Site Development Plan Comments V2.pdf Markup Summary

[1] S-1 Site Development Plan (2)

[2] S-2 Parking Plan (5)

SITE DEVELOPMENT PLAN FOR HONOR CHARTER SCHOOL

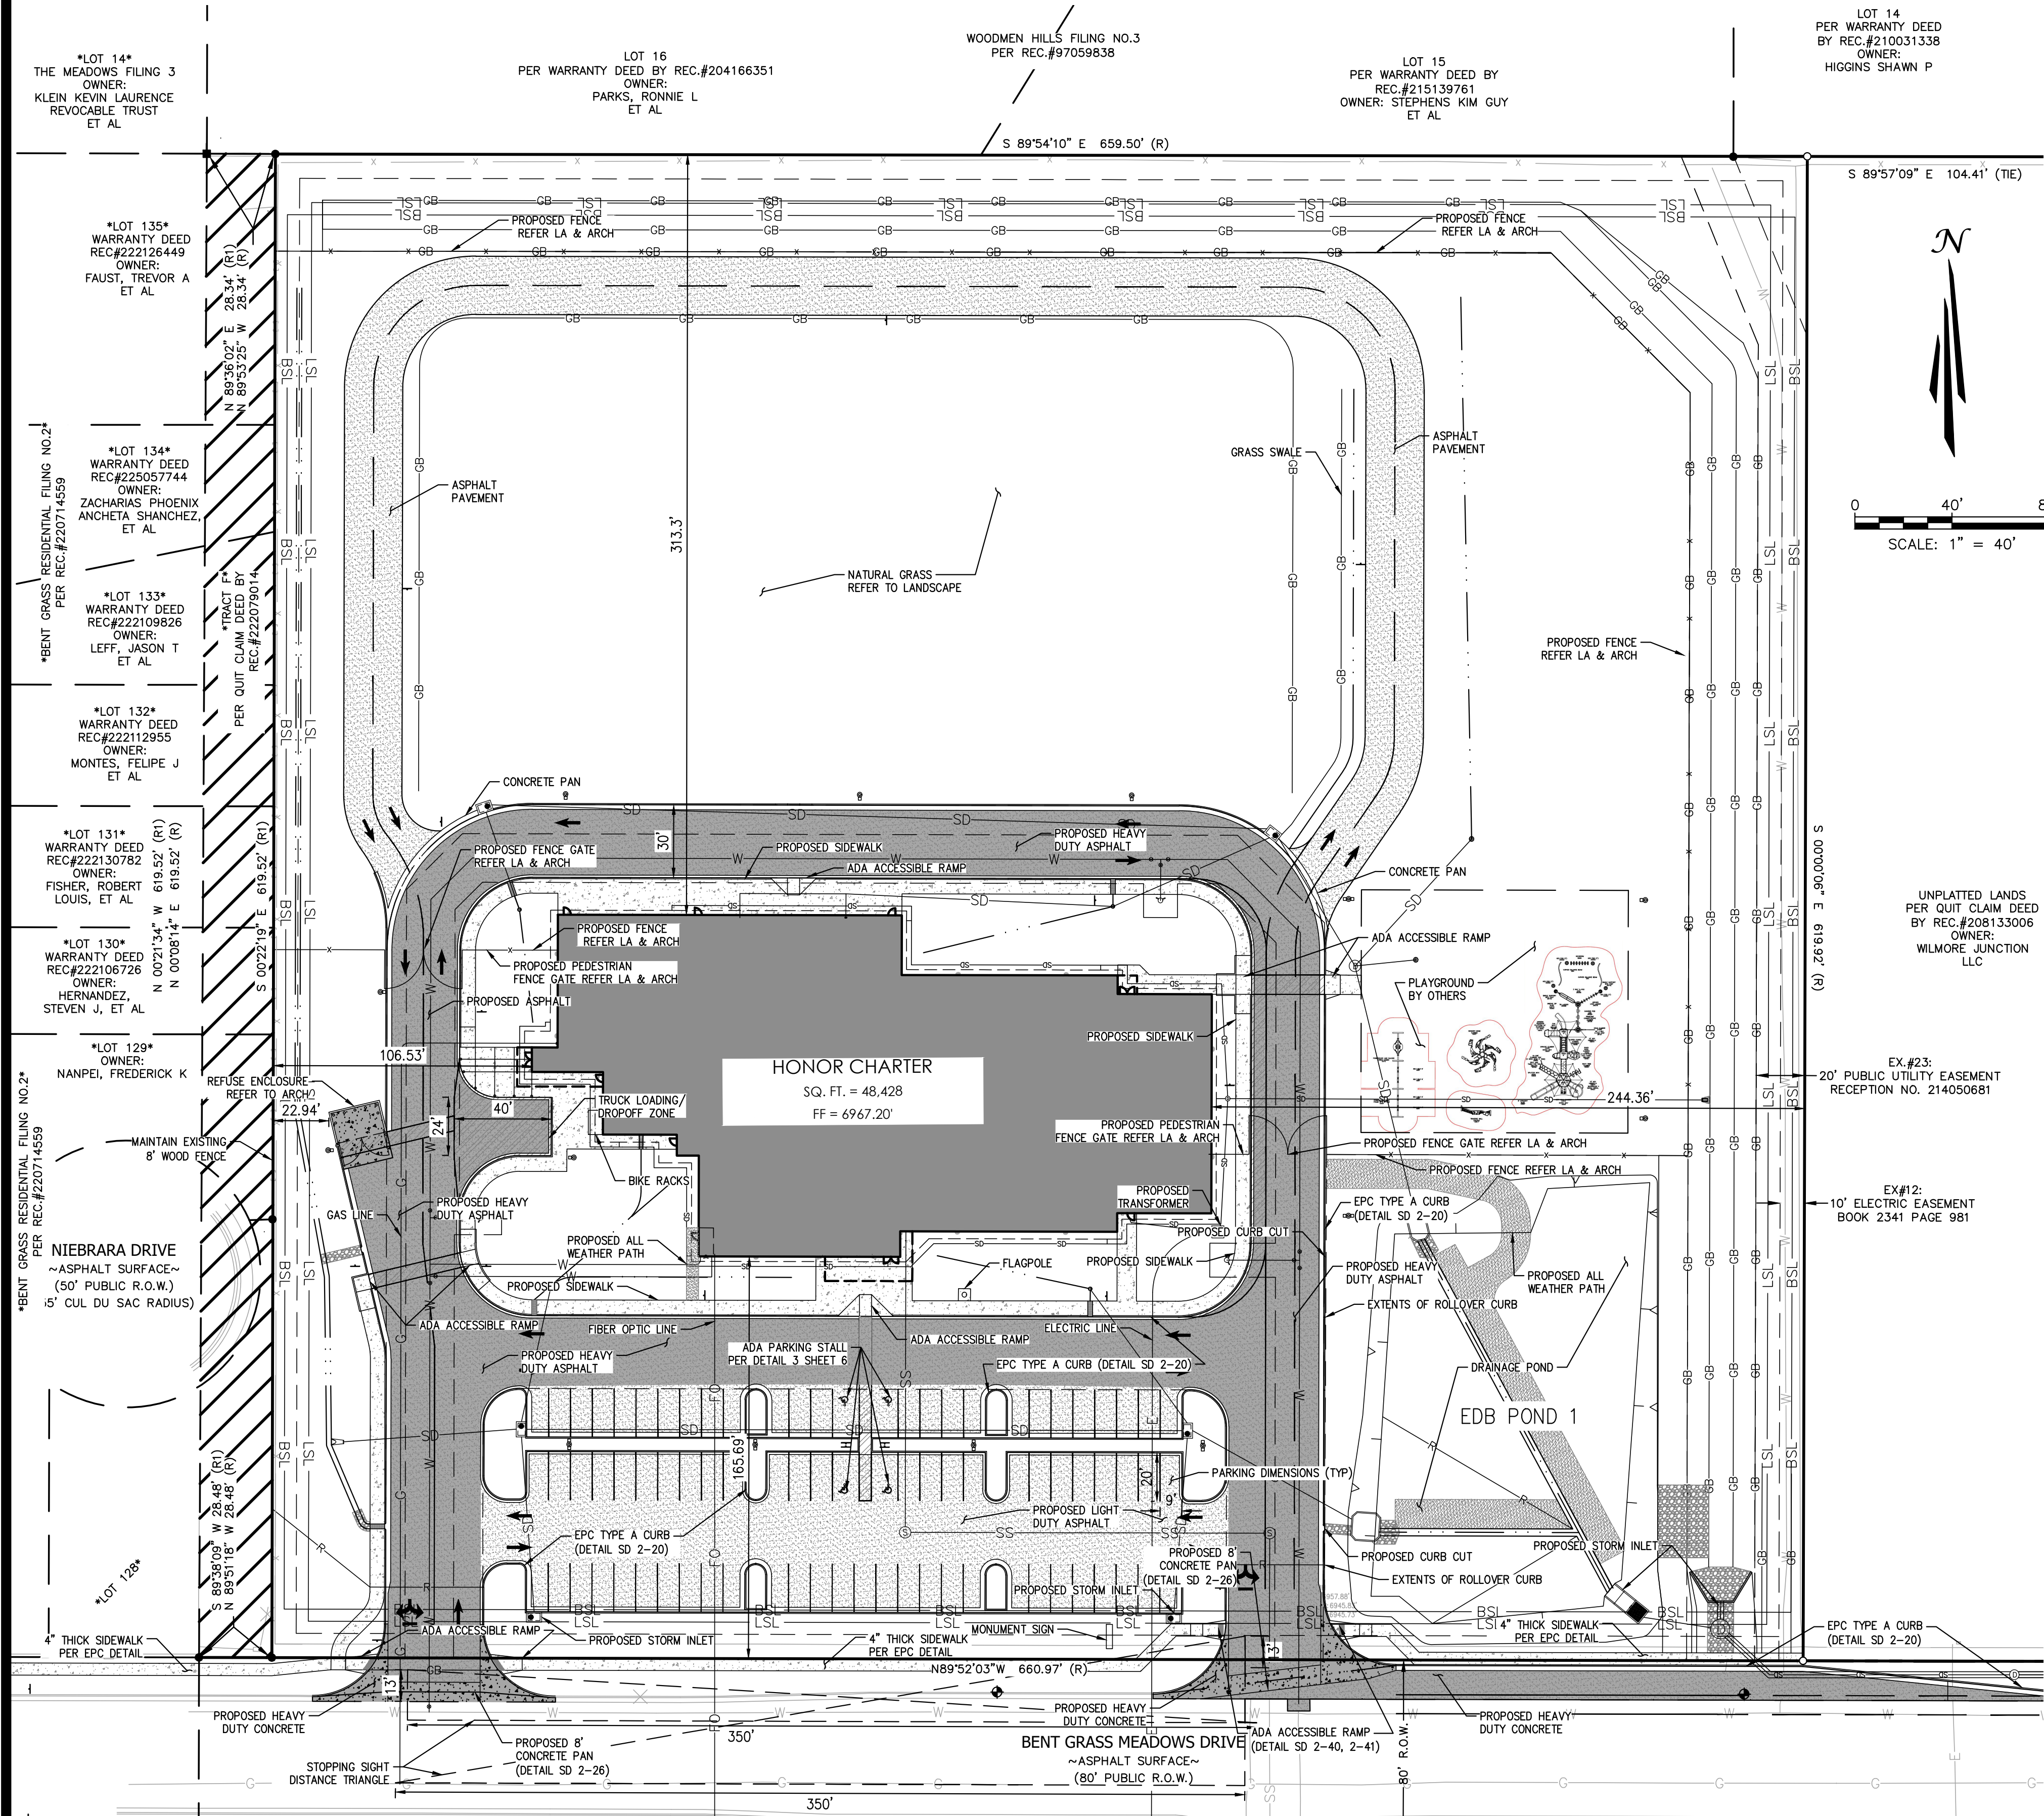
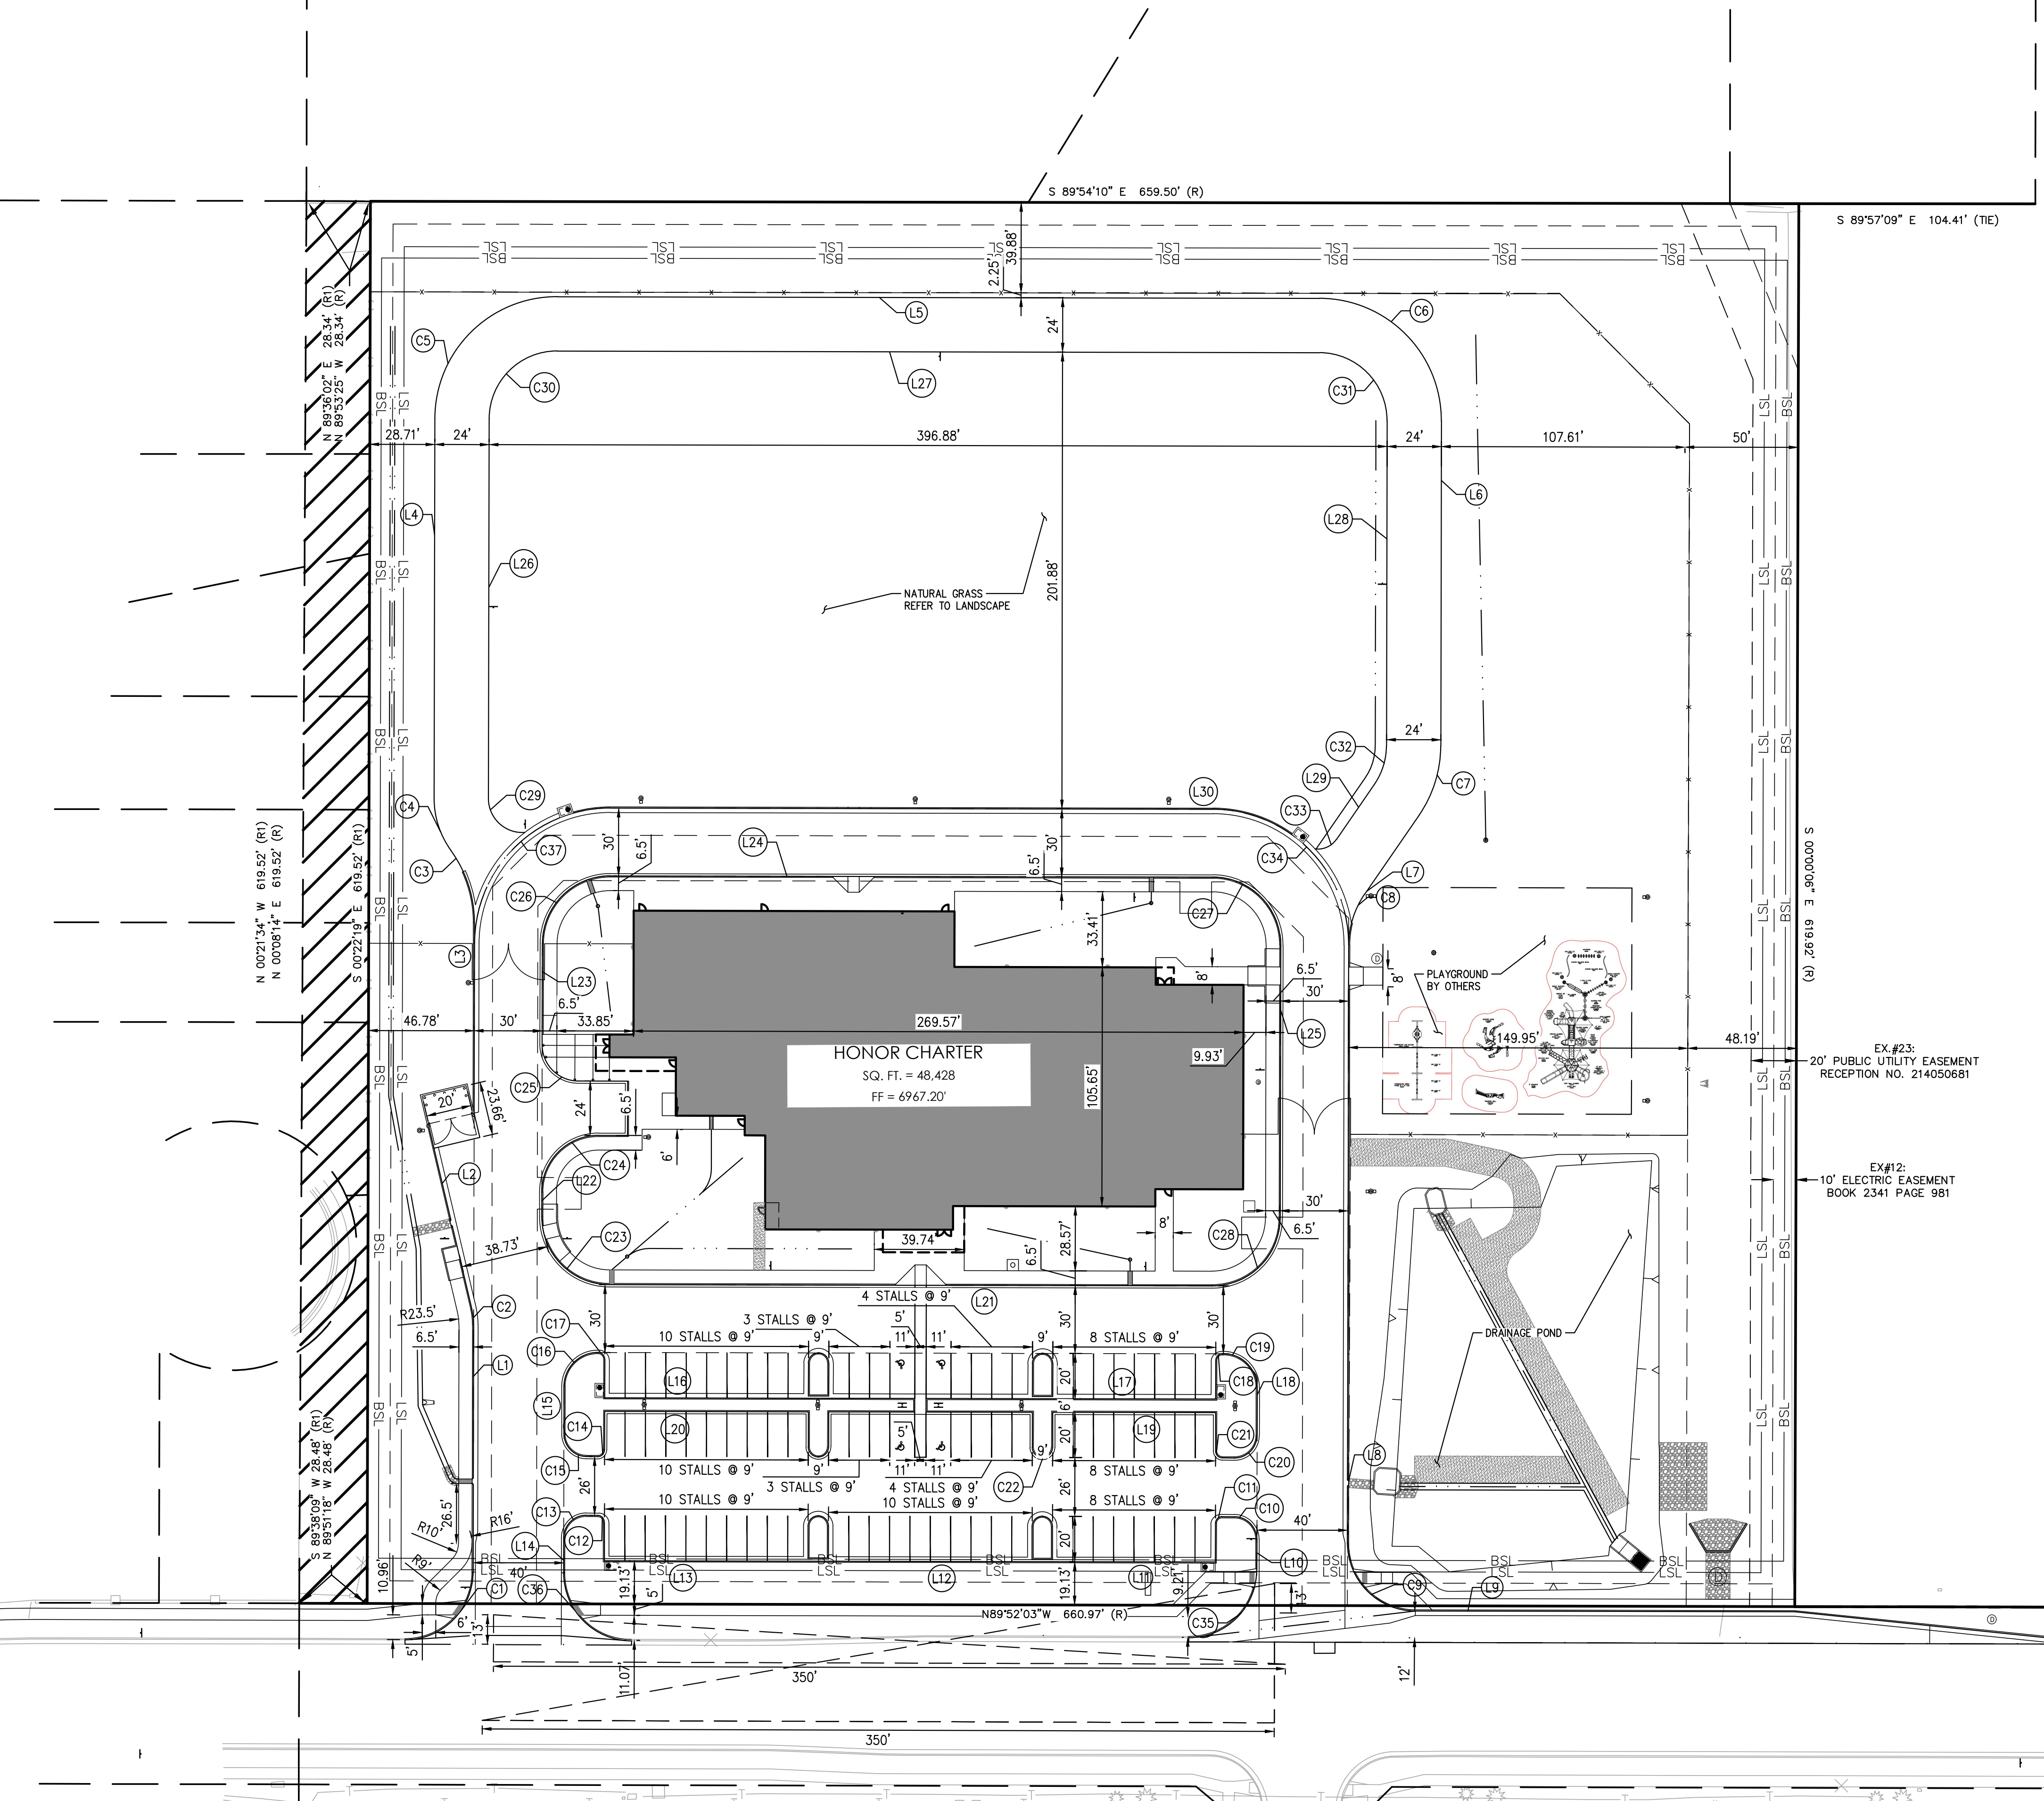
provide the actual setback numbers and 15' buffer at north and west property line required and line.

buffer required at northern and western property lines. PUD Condition of approval

The building setbacks along the north and west have been set to 15'. added screen fence on the north side, and callout on the west side

Dimensions have been added to the site development plan for the buffer/setback distance on each property line.

TAIT Response:
A solid 6' tall wood picket fence will be provided at the northern and western property lines where not already screened by adjacent private fences.
